Planning Application Ref: FP/248/18/T

Location: 29 Westmorland Drive, Felpham PO22 8NA

Description of works: Crown clean & 1-2m reduction on circumference to 1 No. Field Maple tree

29 WESTMERLAND DRIVE

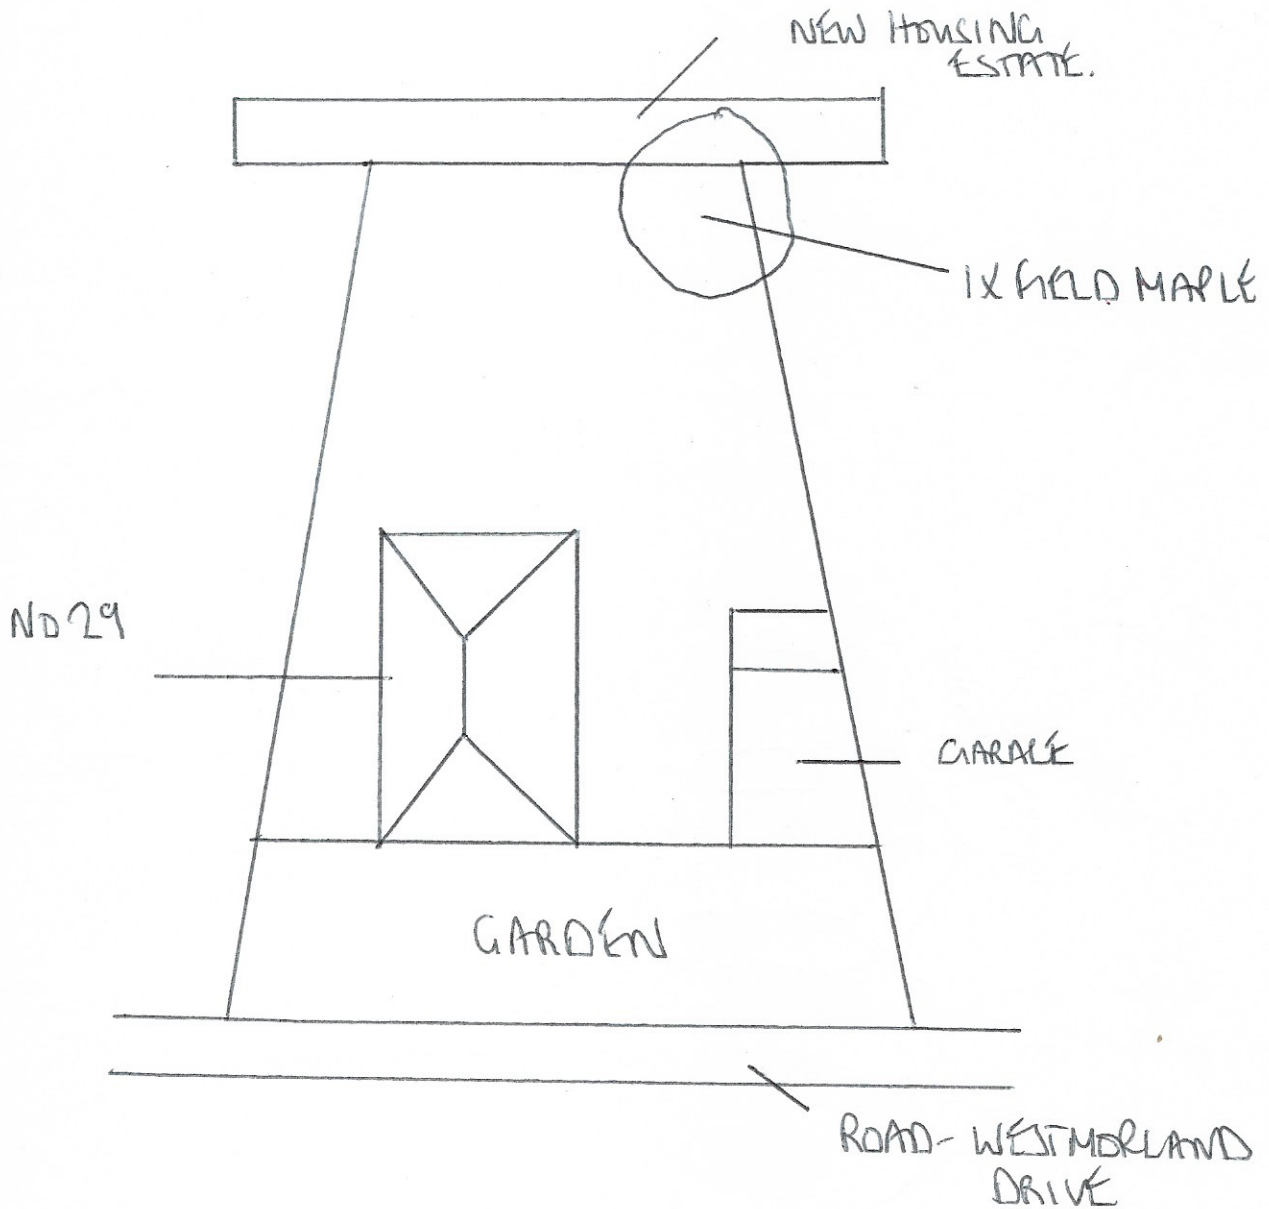
Field maple / *Acer campestre* Height: Approx.8m Average spread: 3m Age class: Mature

- This tree appears to be outwardly healthy and stable with a heavily modified crown. Its growth rate has likely been checked following the recent housing development work locally.
- It forms part of an established boundary tree-line, now placed under considerable pressure arising from the aforementioned development. Crown volume for this tree is low relative to its overall mass- so 1metre should be considered the maximum crown reduction on all aspects (including height) with the exception of property overhang to the west which could tolerate a 2metre reduction.
- It grows at the rear of the property and can be seen from neighbouring dwellings but has only limited visibility from publicly accessible land.

- This tree requires careful management that respects its age and past development pressure.
- If the work is undertaken to a good standard and at the right time; then it is unlikely to have an adverse effect on the tree's long-term vitality.
- There should be no significant loss of public amenity on completion of the proposed works.

- I recommend **CONSENT** for this application, subject to the following conditions:

- Where whole branches are to be removed and final cuts made close to the trunk or branch union they are to be made as shown in Figure 2 of BS3998:2010
- Where branches are to be shortened back the final cuts are to be made at the correct angle shown in BS3998:2010 and adjacent to a live bud or lateral.
- The long-term vitality of this tree is best respected when significant pruning work such as proposed, is undertaken during either the summer (June to August) or mid-winter (mid-December to January) periods. The work proposed must only be undertaken during these periods.
